TOWN AND COUNTRY PLANNING ACT 1990 NON MATERIAL AMENDMENT

Reference: H08-1031-25 **Date of Decision:** 31st October 2025
Applicant: R K Wilson Builders Ltd.
C/O Robert Doughty Consultancy Limited
32 High Street
Helpringham
Sleaford
NG34 0RA
Location: Riseholme Farm Windmill Lane Gosberton Risegate Spalding
Description: Erection of 6 single storey dwellings and garages, formation of parking and bin collection point and reinstatement of existing access - approved under H08-0282-24. Amendments to foundation design to that required under Condition 3 of approval H08-0282-24

South Holland District Council hereby give notice that this application has been REFUSED in respect of the non-material amendments referred to above for the following reason(s):

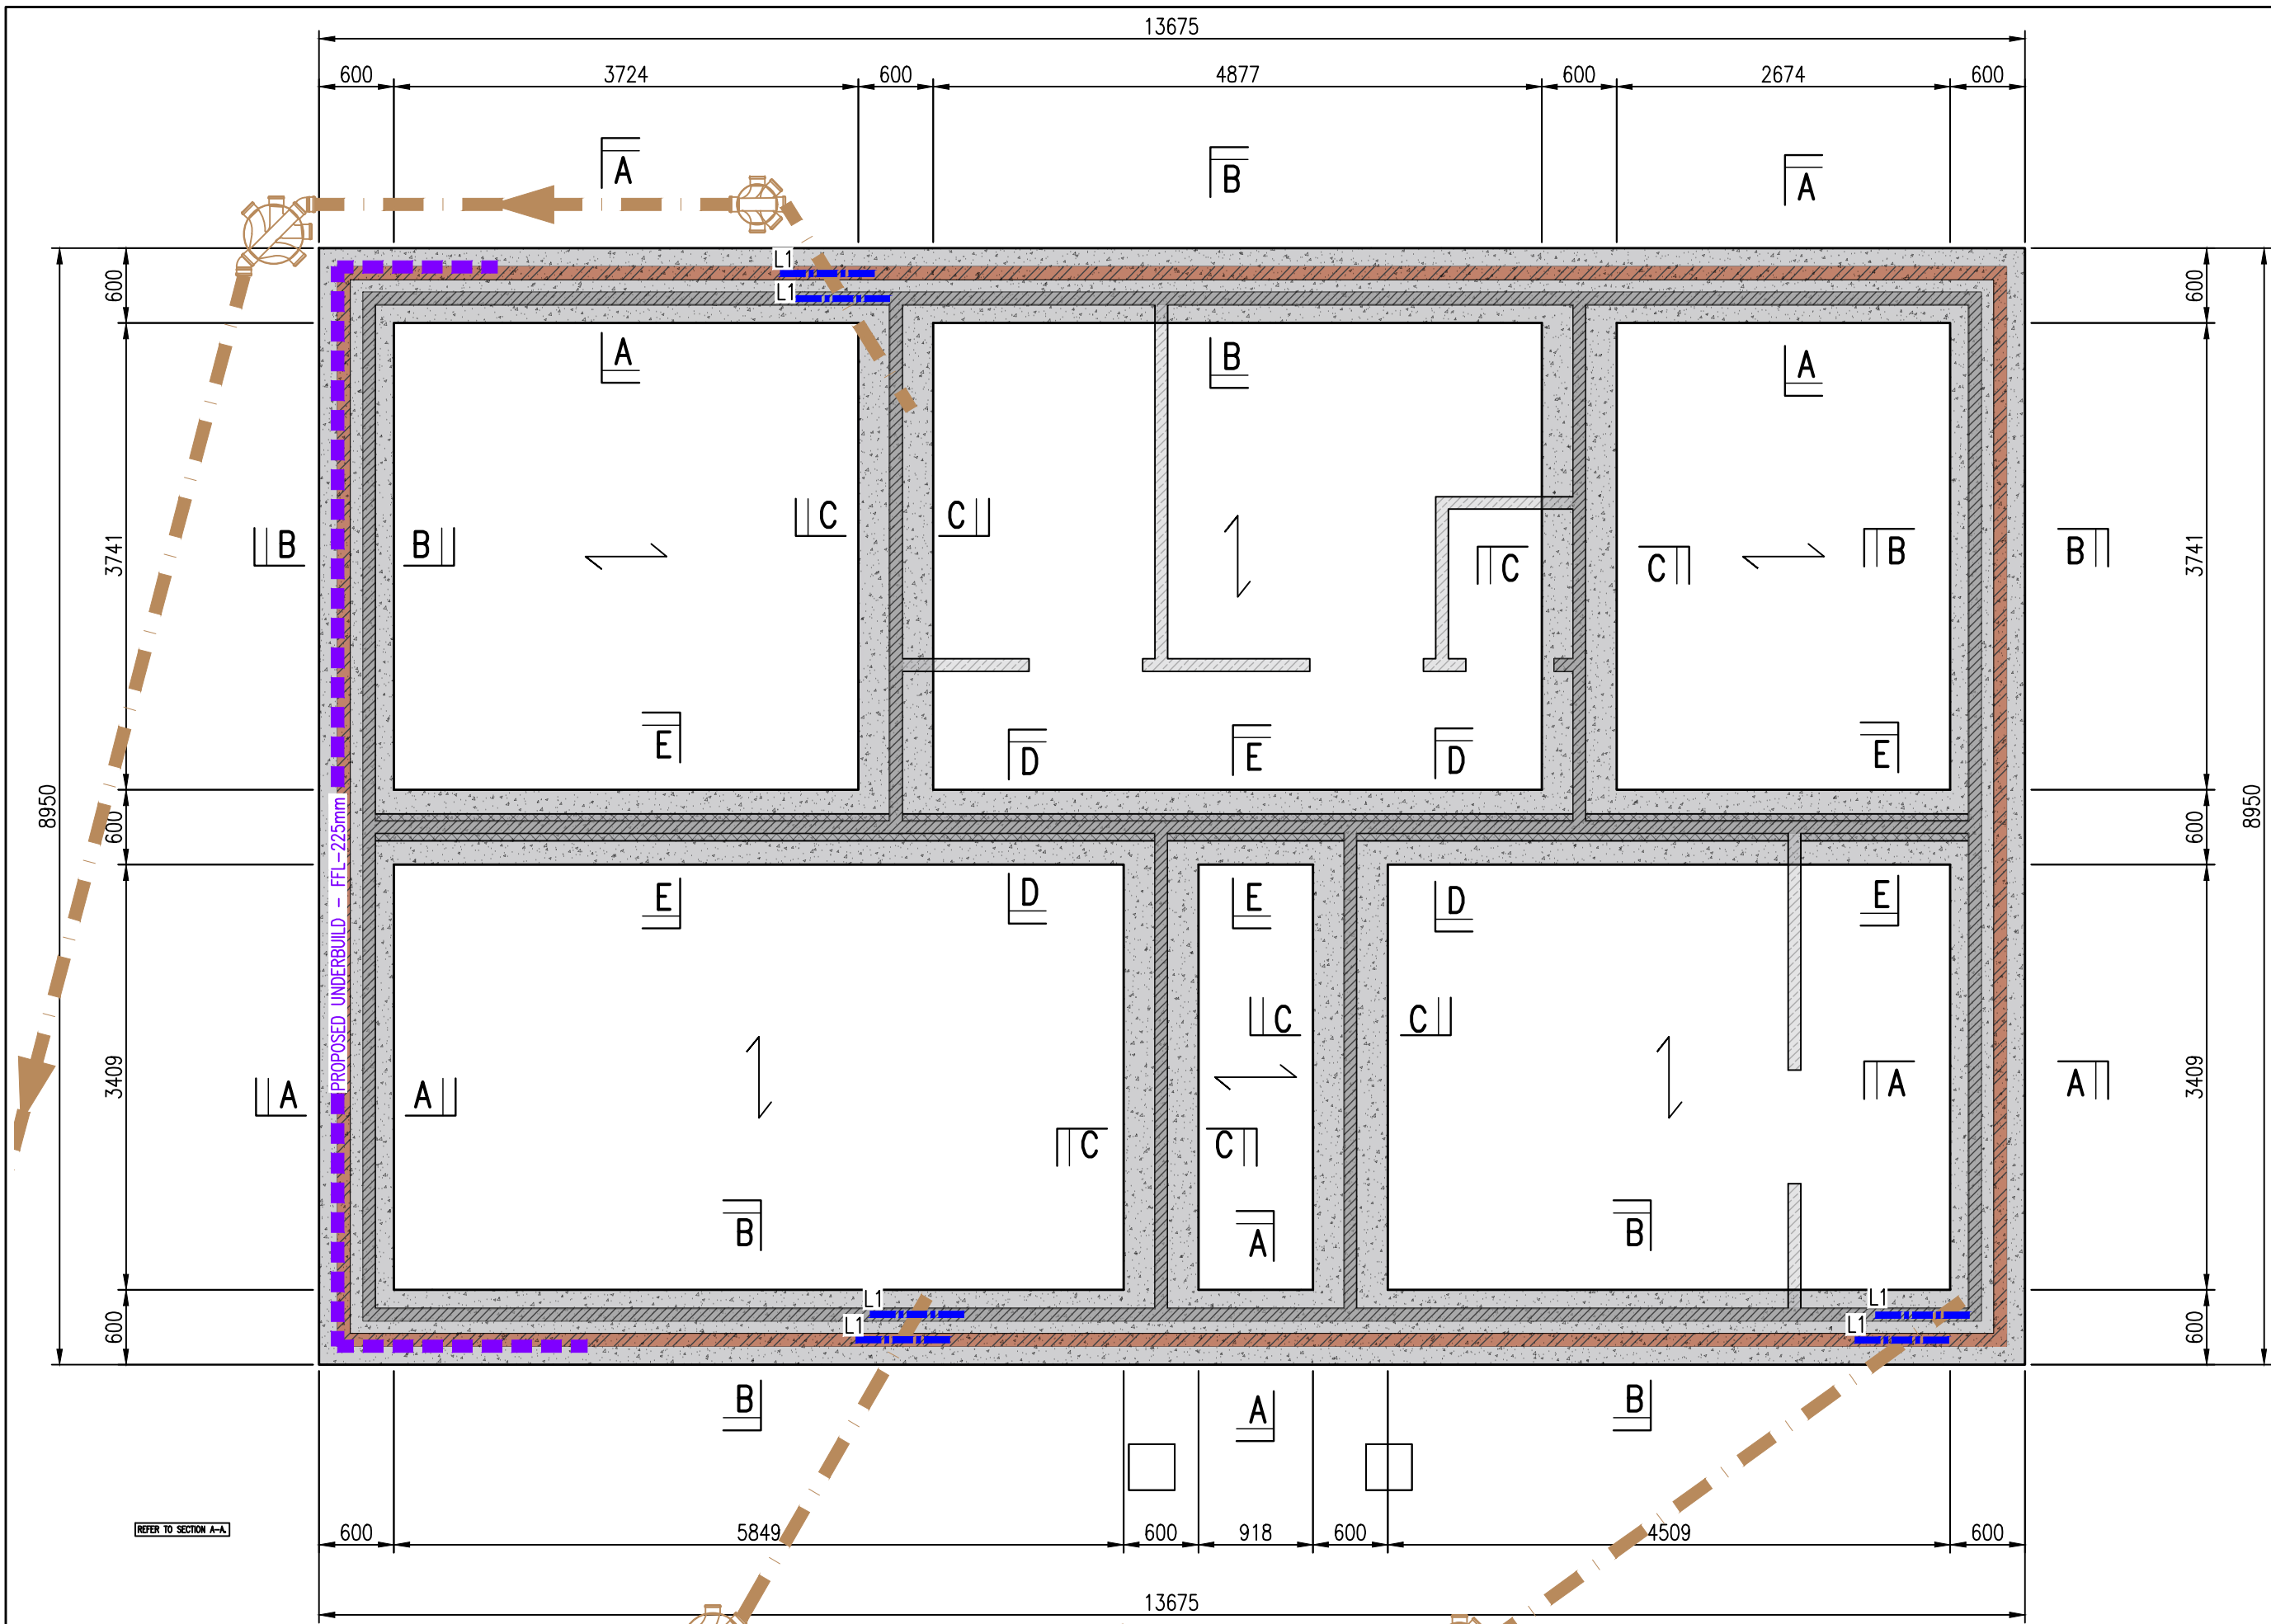
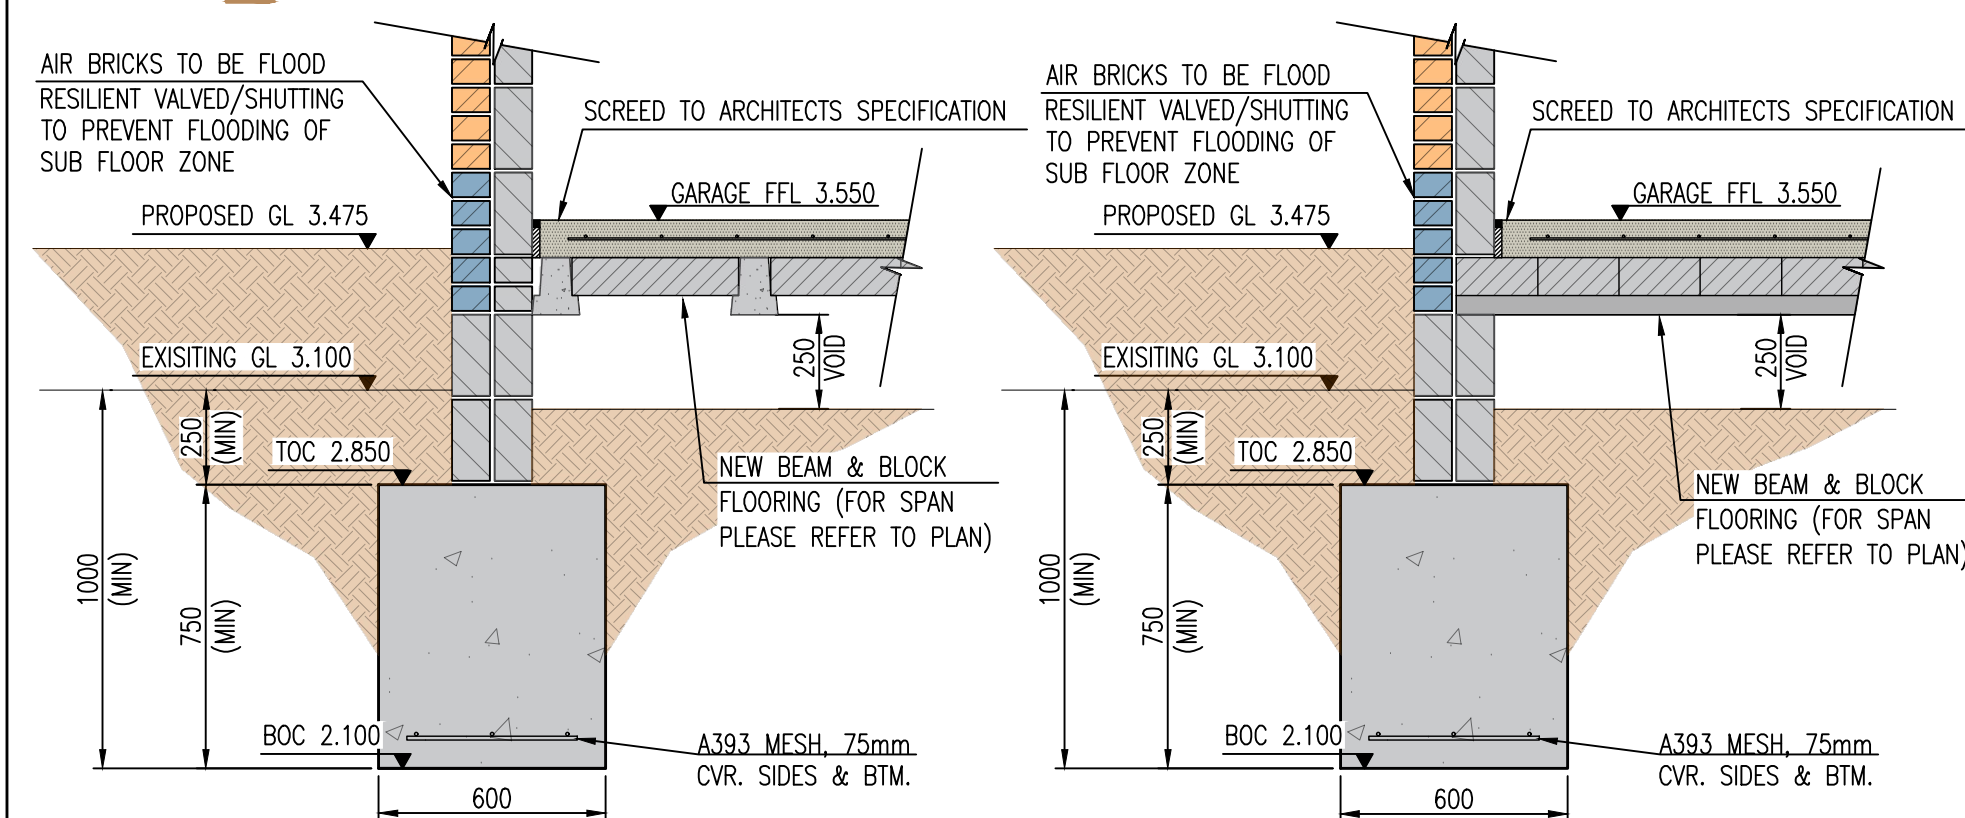
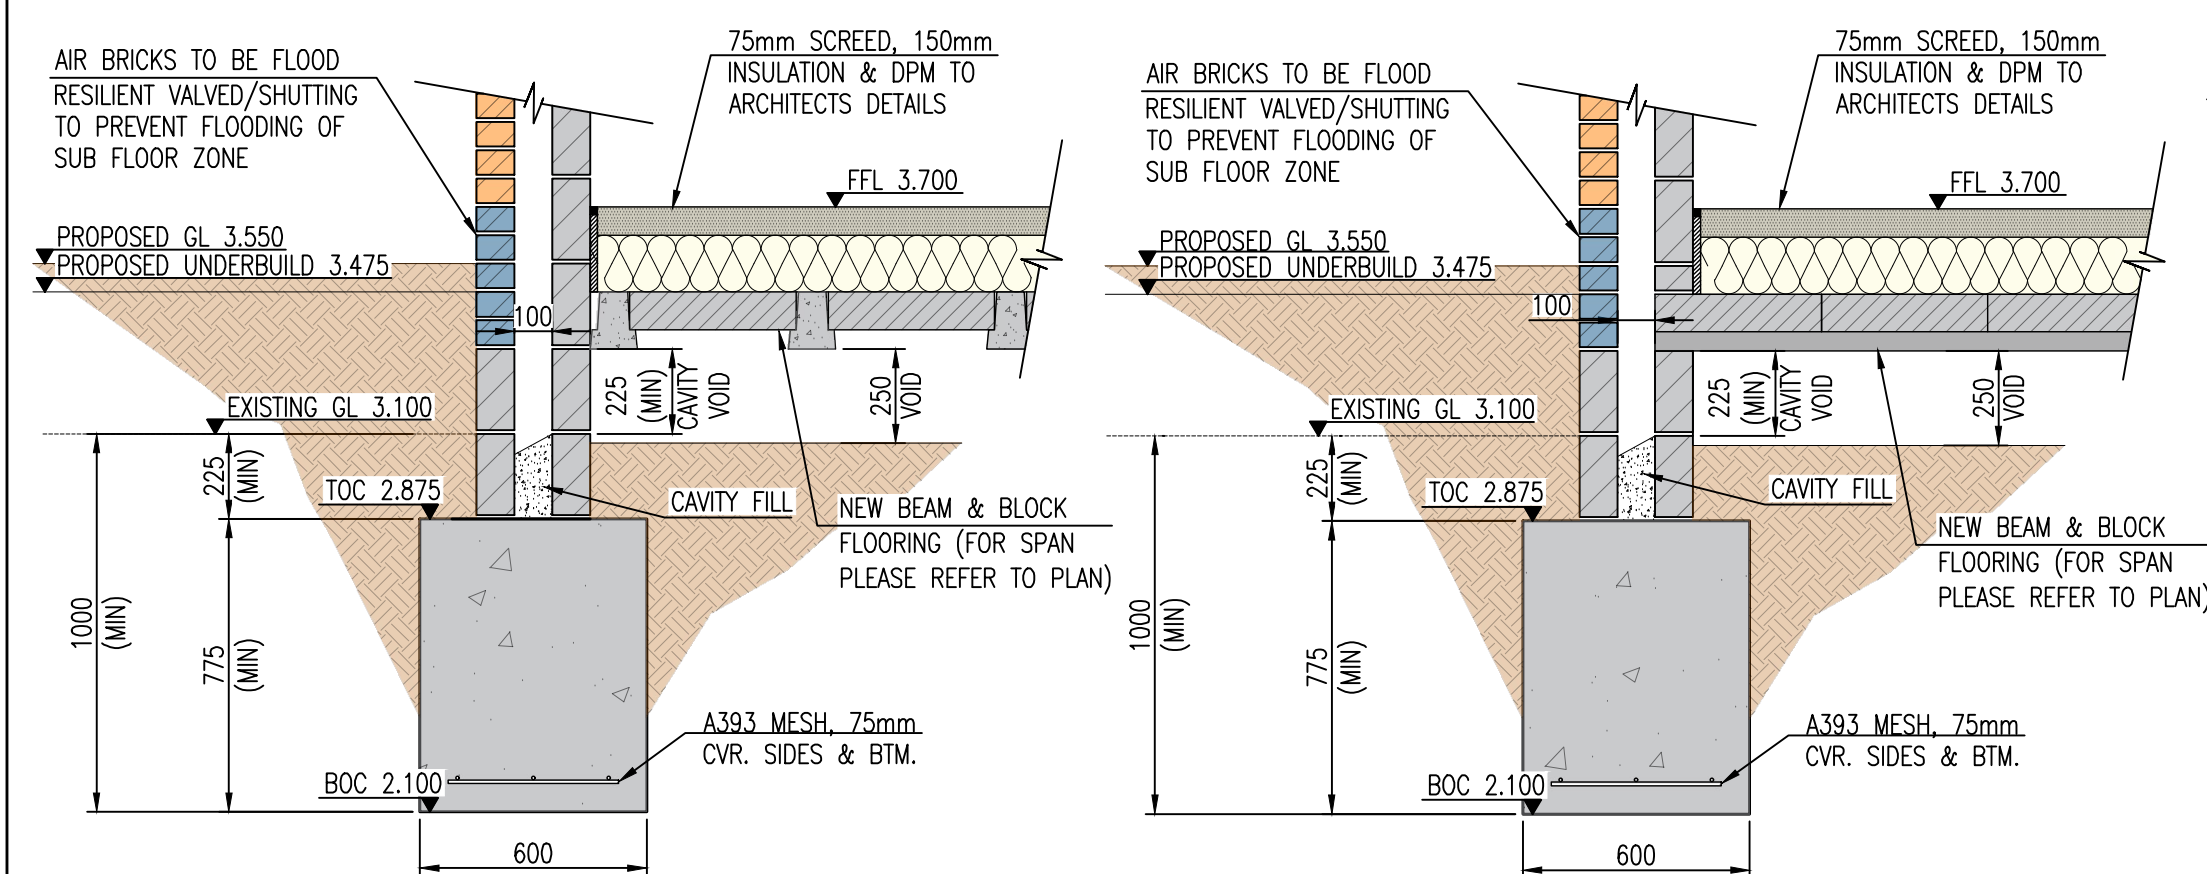
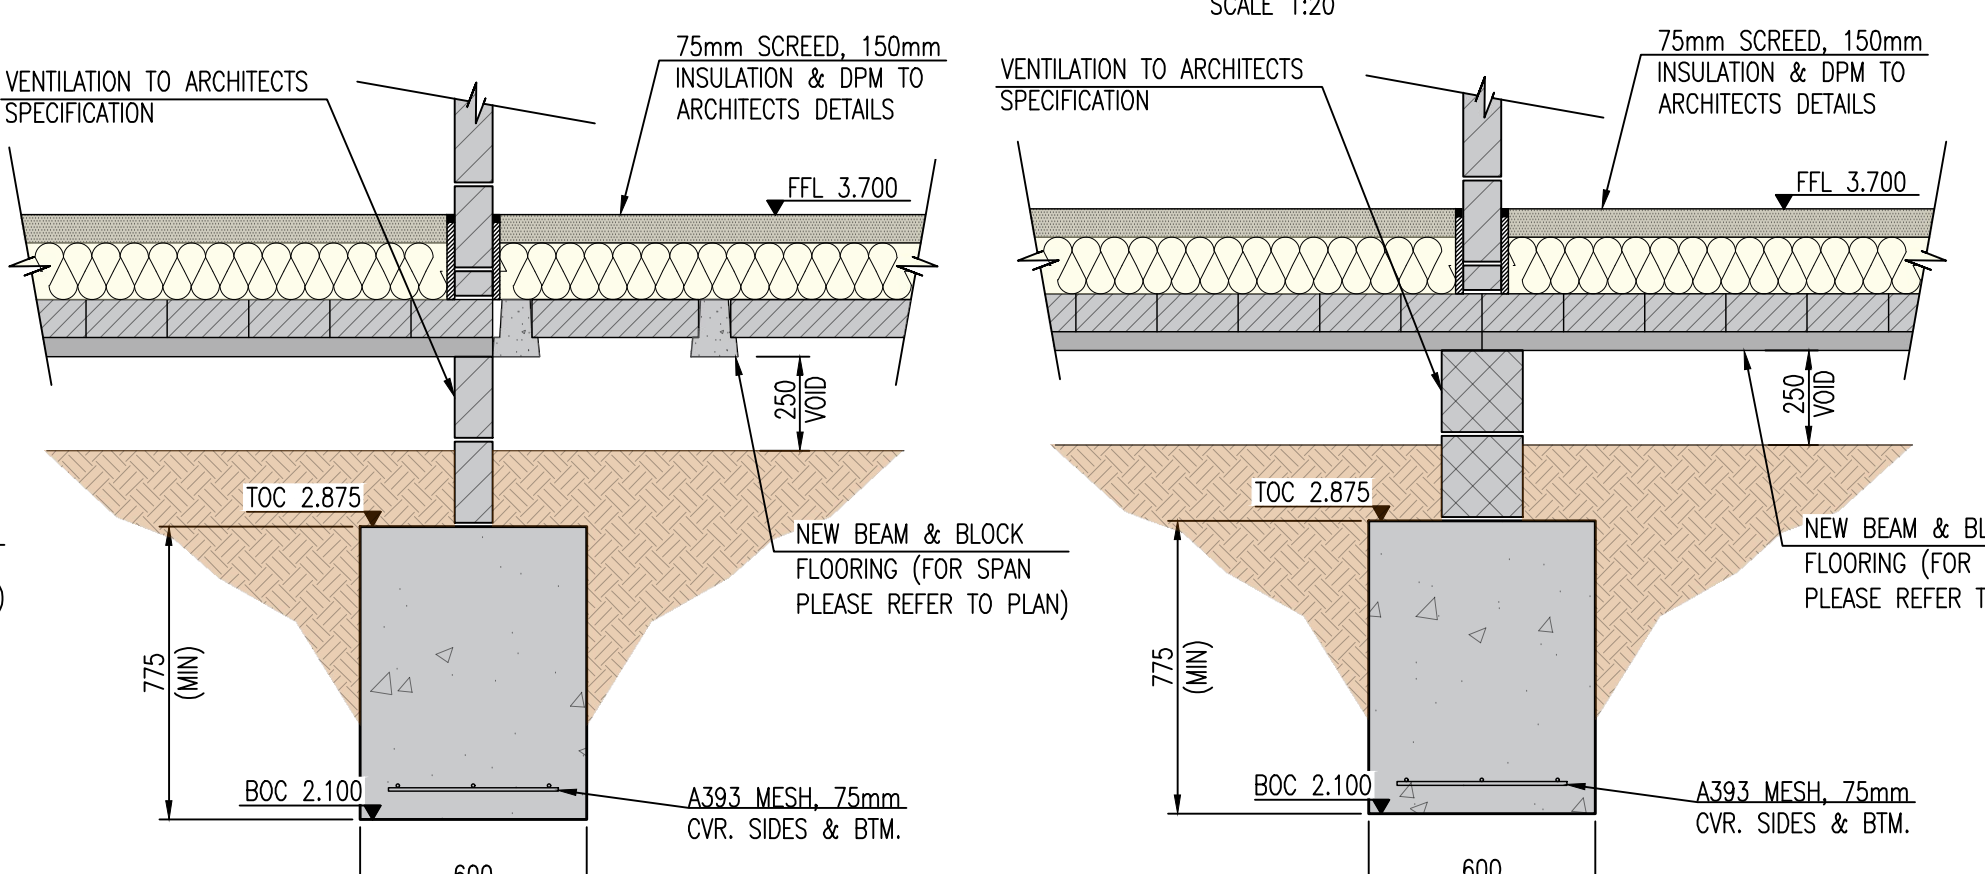
- 1 Point 8 of South Holland District Council's guidance on non-material amendments confirms that such amendments must not result in a fundamental change to the design of the approved building. The approved Flood Risk Assessment (FRA) by RM Associates establishes a critical flood resilience requirement that "the ground floor shall be constructed with a solid concrete floor with no voids beneath and no low-level wall vents." The proposed introduction of a strip foundation incorporating voids beneath the floor would fundamentally alter this key element of the approved design and directly conflict with the flood mitigation measures integral to the scheme's acceptability.

Accordingly, the amendment would constitute a material change to the approved development and cannot be treated as a non-material amendment under Section 96A of the Town and Country Planning Act 1990 (as amended).
